Our Ref: FG/72/18/HH
Your Ref:

Town & Country Planning Act 1990 (as amended)
Town & country Planning (Development Management Procedure) (England) Order 2015
Application for Planning Permission for Works or Extension to a Dwelling

Development Two storey rear extension.
Location 3 Greystoke Mews Ferring

BLOCK PLAN. SCALE 1:500

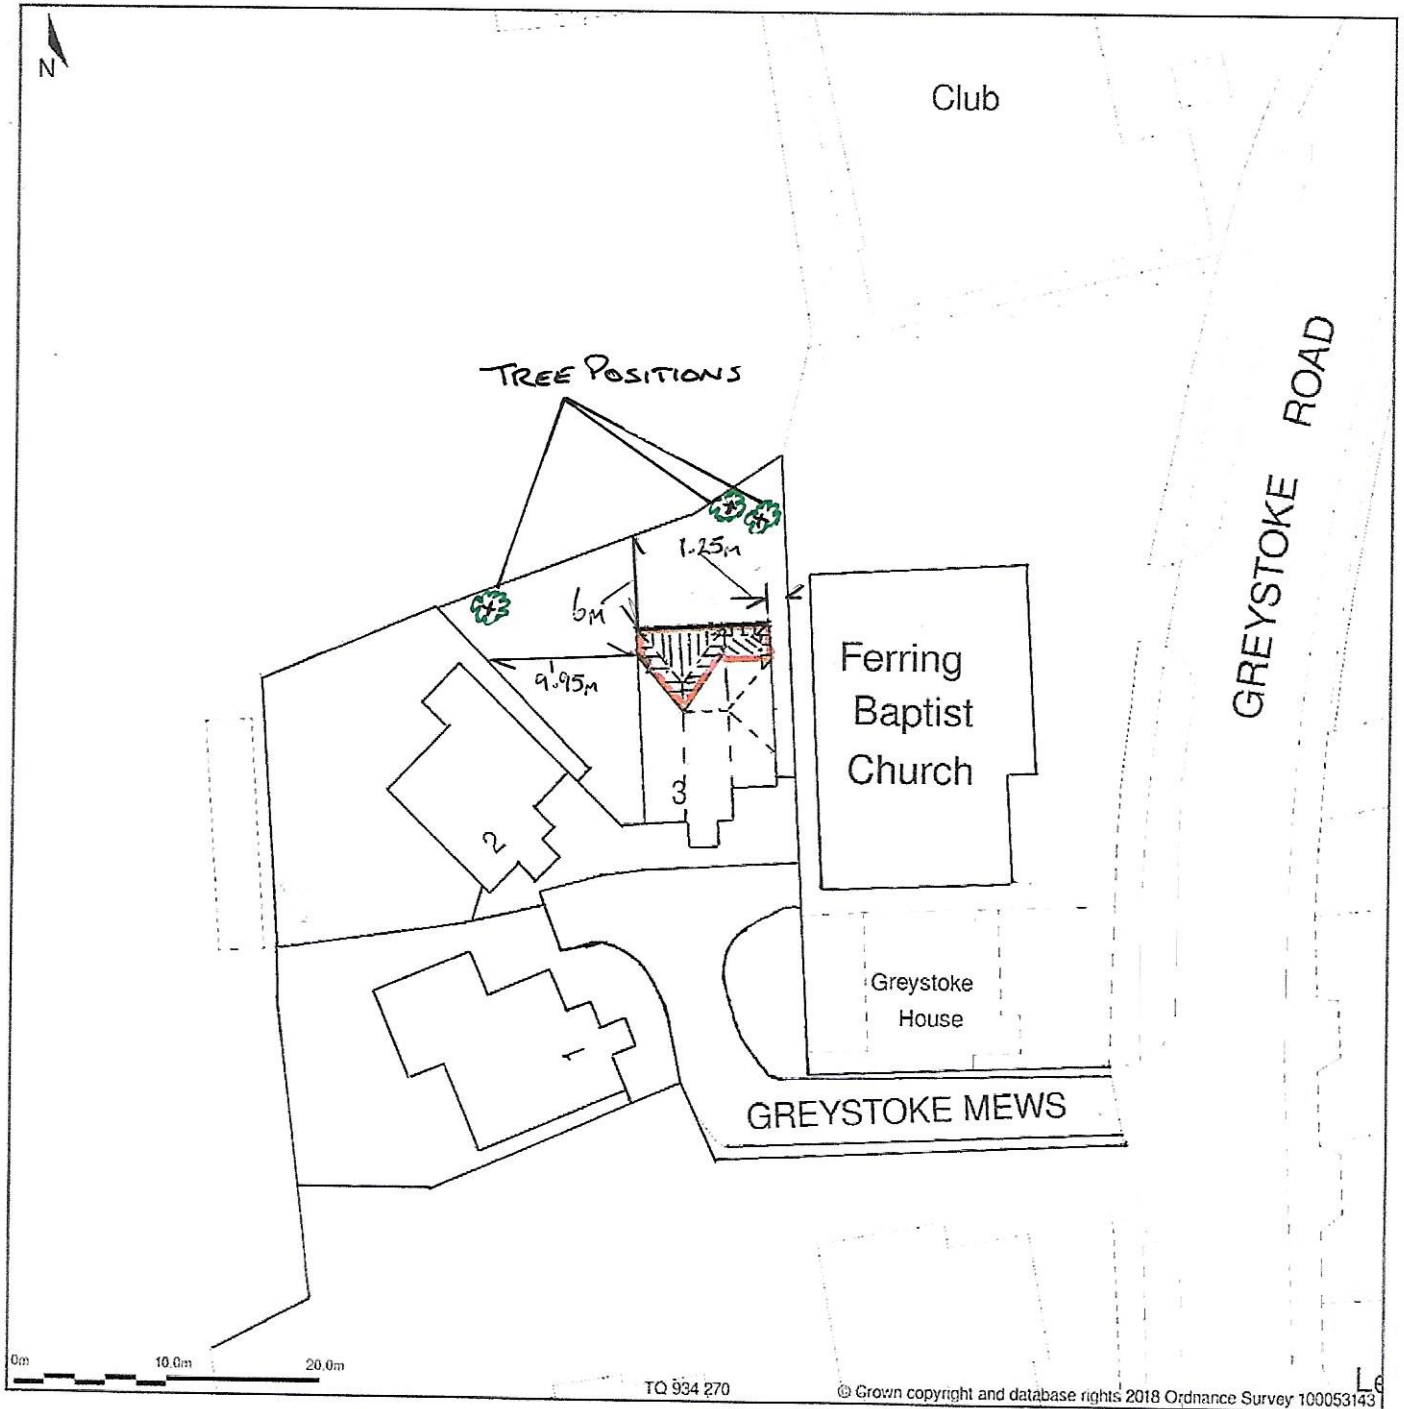
Block Plan Amend

Please submit 1 electronic or 3 paper copies of a block/site plan at a scale of 1:500 or 1:200. Further details of what must be included on the plan can be found in the National Validation Requirements. Please provide measurements from the proposal to the site boundaries.
